From: Linda Griffiths
Sent: 16 March 2020 11:28
To: DC Support
Subject: FW: *EXTERNAL: 19/00213/DISC

From: Judith Ward <Judith.Ward@Cherwell-DC.gov.uk>
Sent: 11 March 2020 14:38
To: Linda Griffiths <Linda.Griffiths@Cherwell-DC.gov.uk>
Subject: RE: *EXTERNAL: 19/00213/DISC

Hi Judith
Please find attached a revised scheme which seeks to overcome your previous objections in respect of Condition 10 of 15/01326/OUT.

Please find attached our contractor's proposals for the combined LAP/LEAP and MUGA facilities in respect to condition 10.

Drawing Title **MULTI USE GAMES AREA
 (MUGA)**

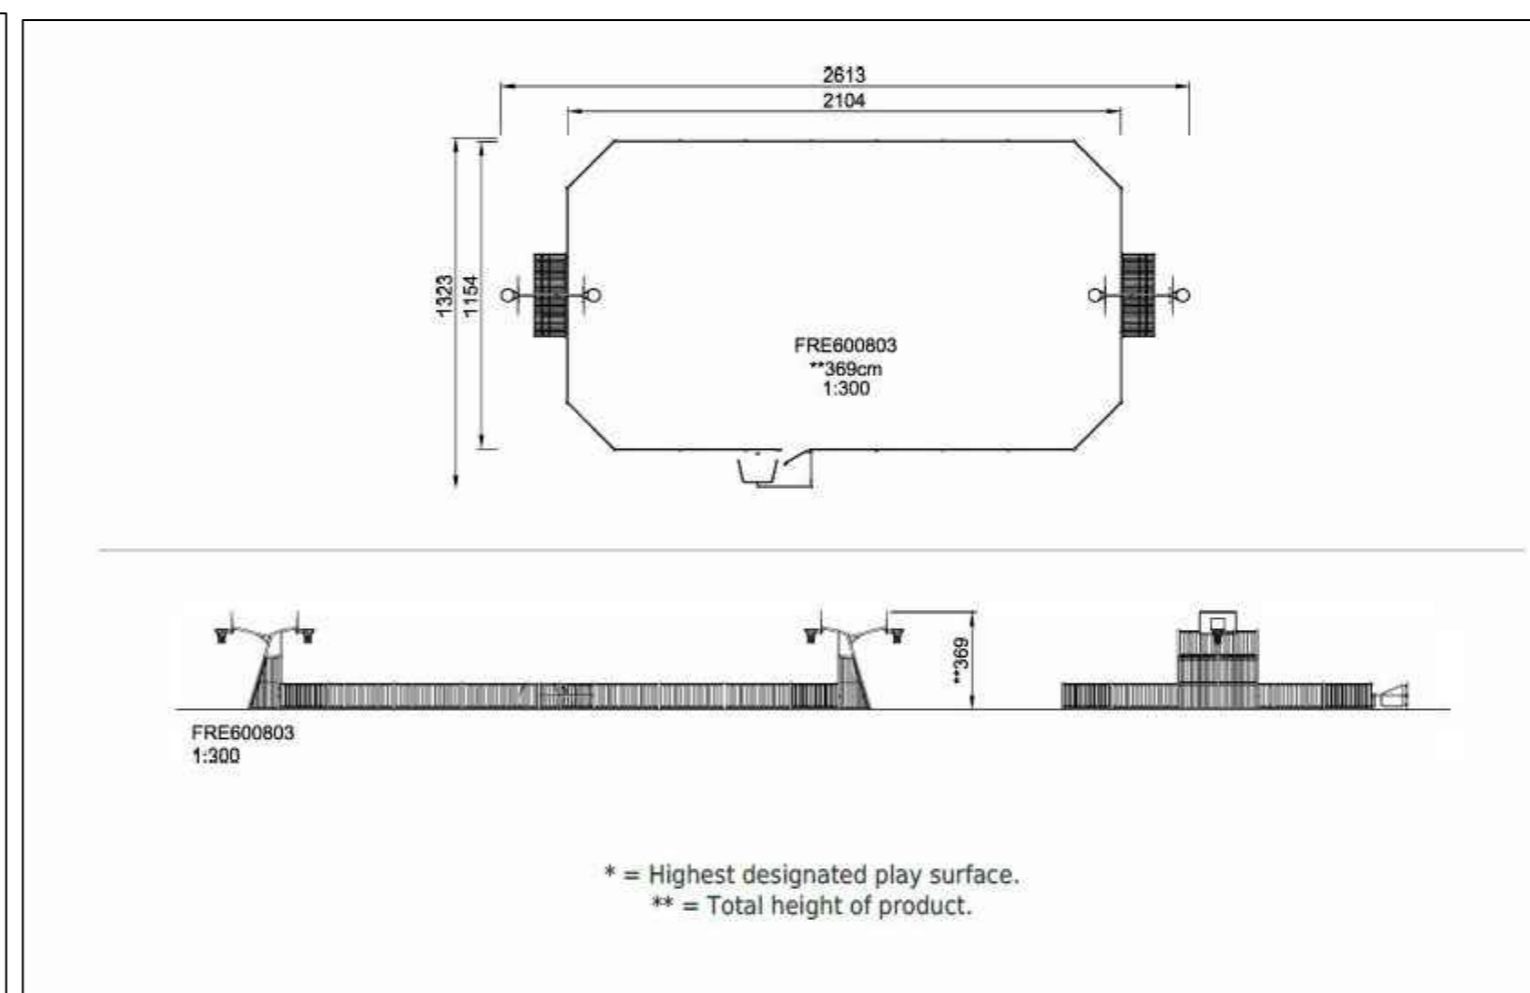
There are some positives with this, at least the MUGA has been moved away from the car park. We will need full details of the MUGA which needs ball fencing 1.2m is not high enough. The previously submitted specification was not adequate. A manufacturer needs to be specified with illustrations provided. Seating is needed for the MUGA. I need to double check the spec with Paul.
